WEST SUSSEX COUNTY COUNCIL CONSULTATION

TO:	Arun District Council FAO: Mrs A Gardner	
FROM:	Highways, WSCC	
DATE:	31 October 2018	
LOCATION:	Garage Premises, Littlehampton Road, Ferring, Worthing, BN12 6PB	
SUBJECT:	FG/171/18/DOC Approval of details reserved by condition imposed under FG/39/18/PL relating to conditions 3-surface water drainage, 4-ground contamination risk, 9-position & intensity of lighting filments, 14-lighting scheme, 15-Construction Management Plan & 16-ground contamination risk.	
DATE OF SITE VISIT:		
RECOMMENDATION:	☐ Advice ☐ Objection ☐ Modification ☐ No Objection ☒ More Information ☐ Refusal	
S106 CONTRIBUTION TOTAL:

Condition 15 – Construction Management Plan

Plans considered; Site Construction Management Plan 17036-HNW-00-XX-D-R-A-W112, Site Demolition Plan, Construction Management Plan (HNW).

APPENDIX C – DELIVERY VEHICLE (LARGEST ANTICIPATED) TURNING HEAD PLAN

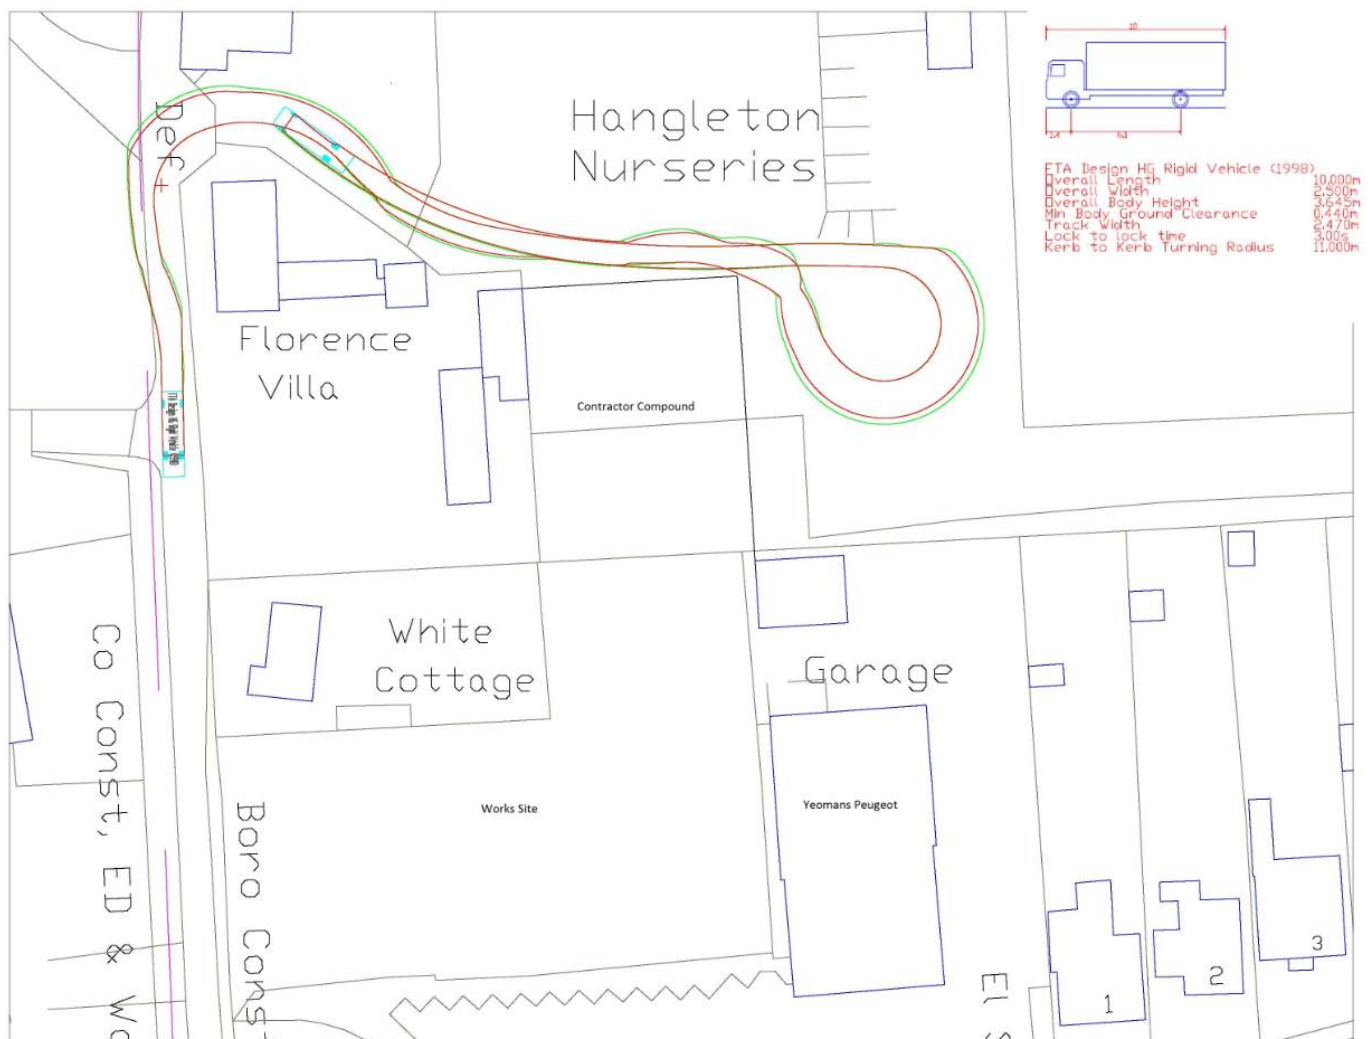
- Maximum size of delivery vehicles. The CMP states no articulated vehicles will be used however rigid vehicles can have a limited turning circle.
- Swept paths for maximum vehicle size of; the access and of turning within the site. Swept paths should be shown on the CMP with all other obstructions ie parking also shown.
- Details of any extra large plant expected ie Cranes.
